Appeal Decision

Appeal Ref: APP/R4408/D/24/3343329

12 Badsworth Close, Wombwell, Barnsley S73 0YR

- The appeal is made under section 78 of the Town and Country Planning Act 1990 (as amended) against a refusal to grant planning permission.
 - The appeal is made by Mr Raymond Law against the decision of Barnsley Metropolitan Borough Council.
 - The application Ref is 2024/0026.
 - The development is described as: 'retrospective planning application for the construction of carport forward of the principle elevation.'
-

DRG No CAD/001

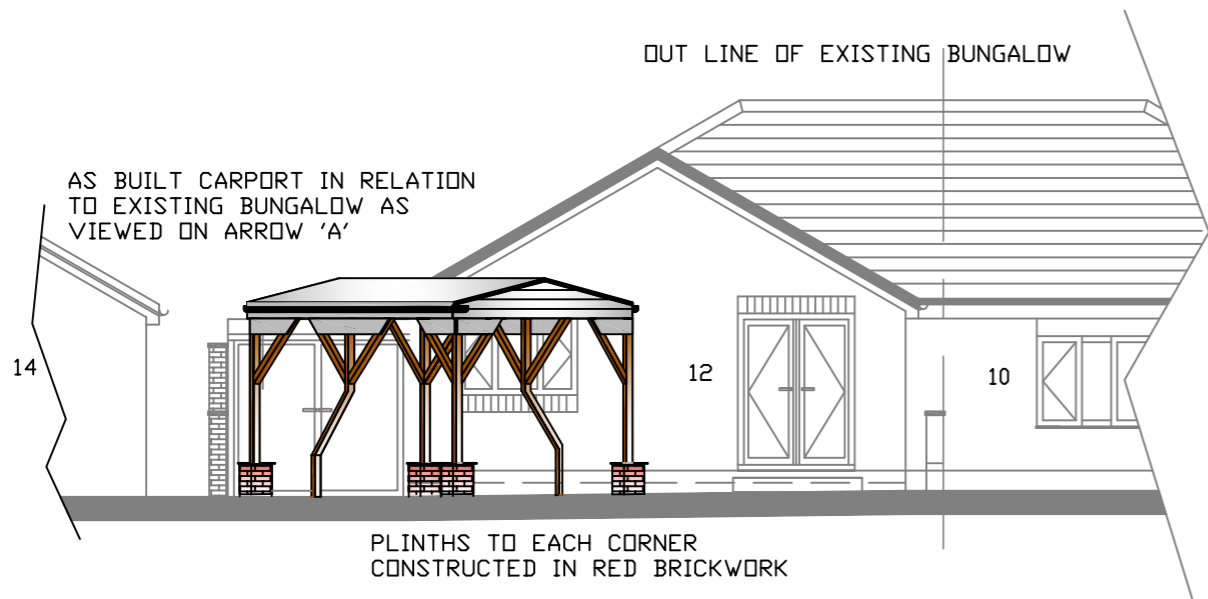
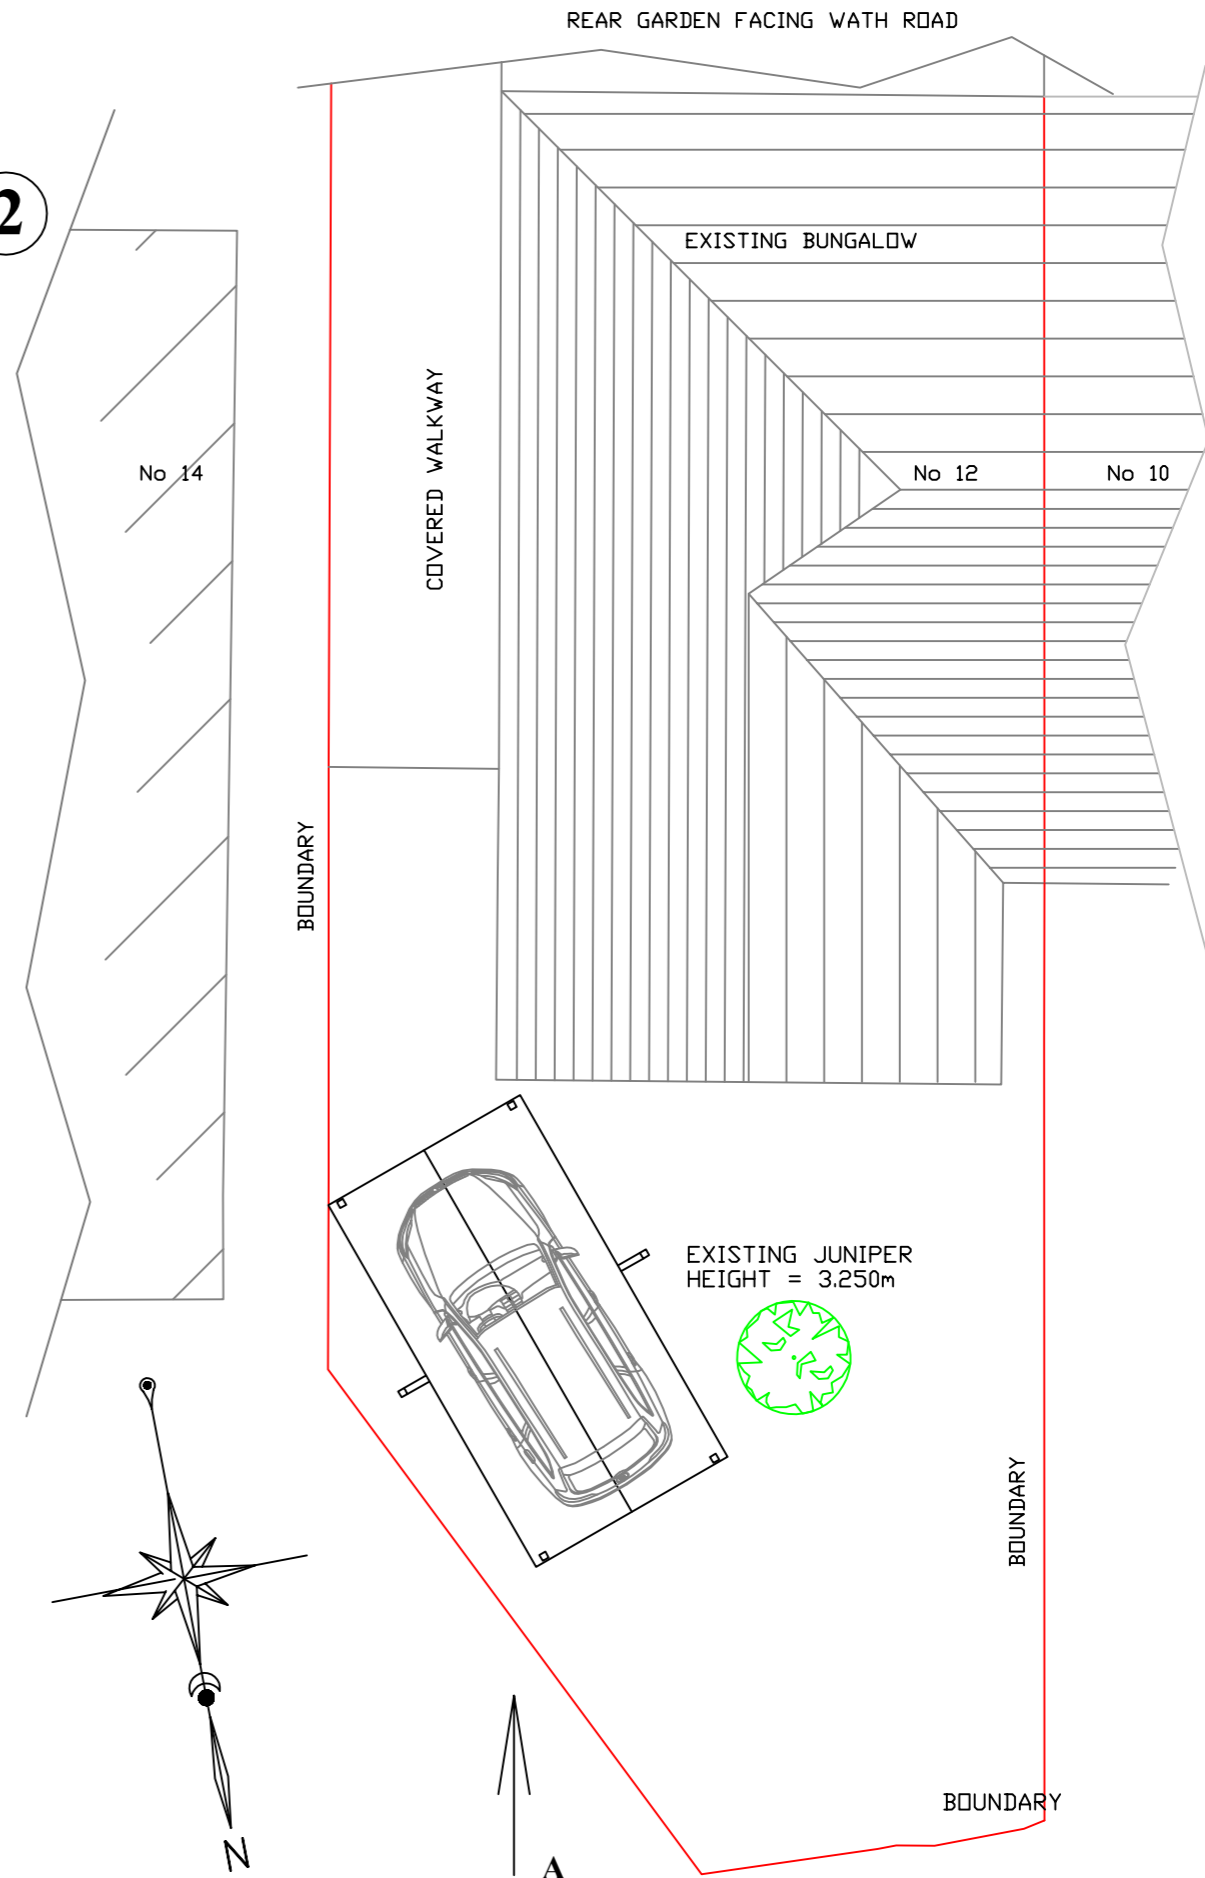
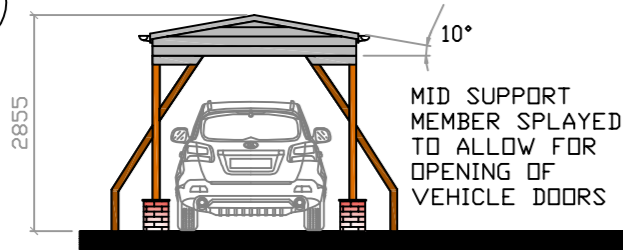
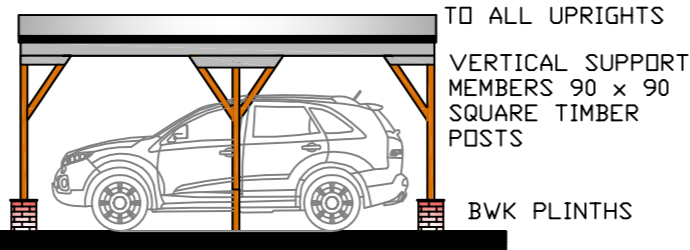
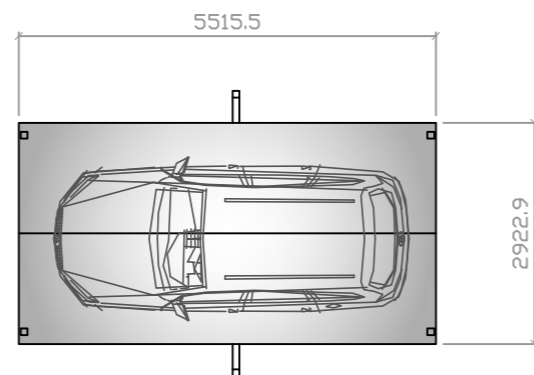
6. The carport sits in an angled position to the front of No 12 and forward of the neighbouring dwellings to either side (Nos 8 and 10). There are no other similar carports or other outbuildings within the frontages to the properties in this part of Badsworth Close. Even accounting for its open sides, the shallow pitched roof and the materials, both of which contrast with the form and appearance of the host dwelling, do not relate sympathetically to the cohesive character or appearance of the locality. Together with its prominent location within the frontage of the host dwelling, the development appears incongruous amongst the generally open frontages which characterise the street.

7. Either side of the carport is a low-level panelled fence between brick piers which share front garden boundaries with No 10 and No 14. There is also an existing tree located immediately adjacent to the carport. However, these features provide limited screening from public vantage points and do not negate the harm identified.

8. I conclude that the development has had a harmful effect on the character and appearance of the area. In this regard, the development conflicts with Policy D1 of the Barnsley Local Plan (2019) (LP) which expects development to be of a high-quality design and to respect and reinforce the distinctive, local character and other features of Barnsley.

9. The design of the car port also conflicts with the guidance in the SPD 2024 which advises that outbuildings should relate sympathetically to the main dwelling in style, proportions and external finishes. The appellant suggests that the SPD 2024 is not relevant as it does not explicitly refer to carports. A carport is akin to an outbuilding and in any case, the development conflicts with the character and appearance requirements of the LP. It is also contrary to the National Planning Policy Framework (2023), insofar as it requires planning decisions to ensure that development establishes or maintains a strong sense of place, using the arrangement of streets, spaces, building types and materials to create attractive, welcoming and distinctive places to live.
